Consultation Response from: KC Environmental Health (Pollution & Noise Control)

2021/91537 - Dearne Grange Farm, Park Head Lane, Birds Edge, Huddersfield, HD8 8YA

Discharge conditions 3, 4, 14, 16 on previous permission 2020/91484 for demolition of stable block and erection of detached dwelling

Date Responded:
23rd June 2021

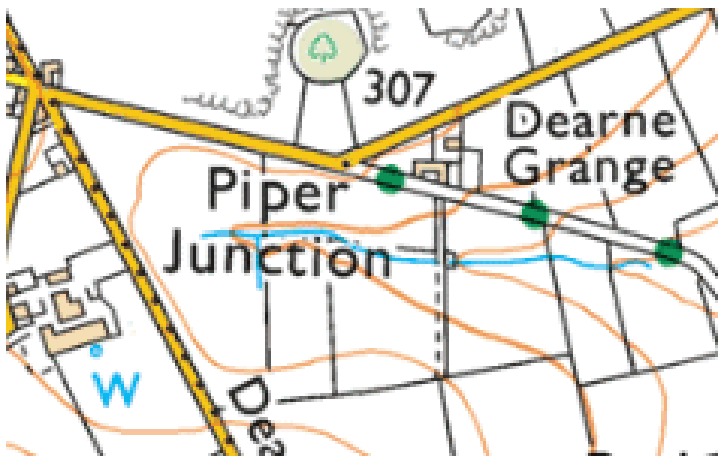
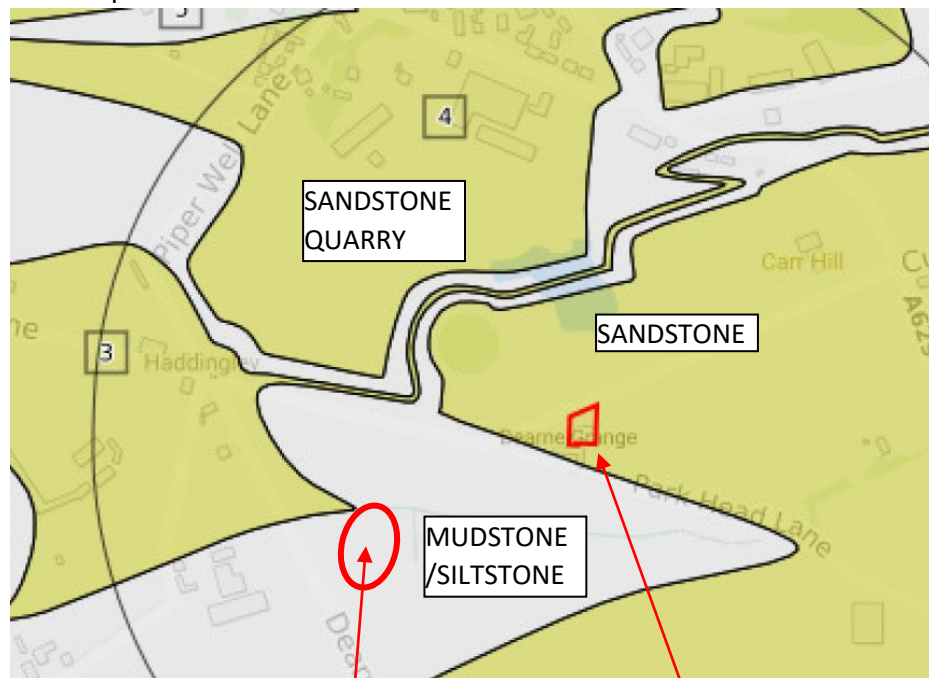
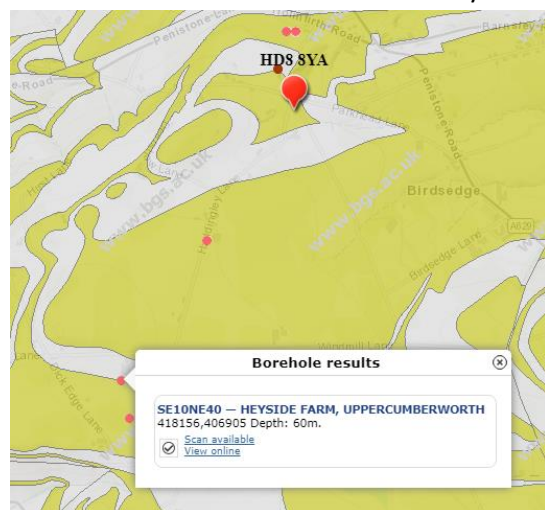
Since then, we identified to the applicant an area of infilled ground (our reference: 71/22) within 250m of the site which had not been considered in the Phase II report. In response, a supporting contaminated land risk assessment dated 18th June 2021 by Geo Investigate has been received. The report includes geo-technical information, which is outside the remit of Environmental Health, this consultation response therefore only relates to the land contamination aspects of the report.

In the new information, Geoinvestigate first question the reliability of the record provided by this service. Next, the report gives reasons as to why the infilling in this area would not pose a risk to the development in relation to topography and geology. Briefly, the author states that due to the contour of the land ground gas migration would be unfeasible. This is supported by a discussion provided about geology.

It is encouraging to see a supporting discussion that justifies the absence of ground gas monitoring at the site. Having read the report provided, we are now satisfied that the ground gas risk has been determined at the site and that Condition 4 should be discharged.
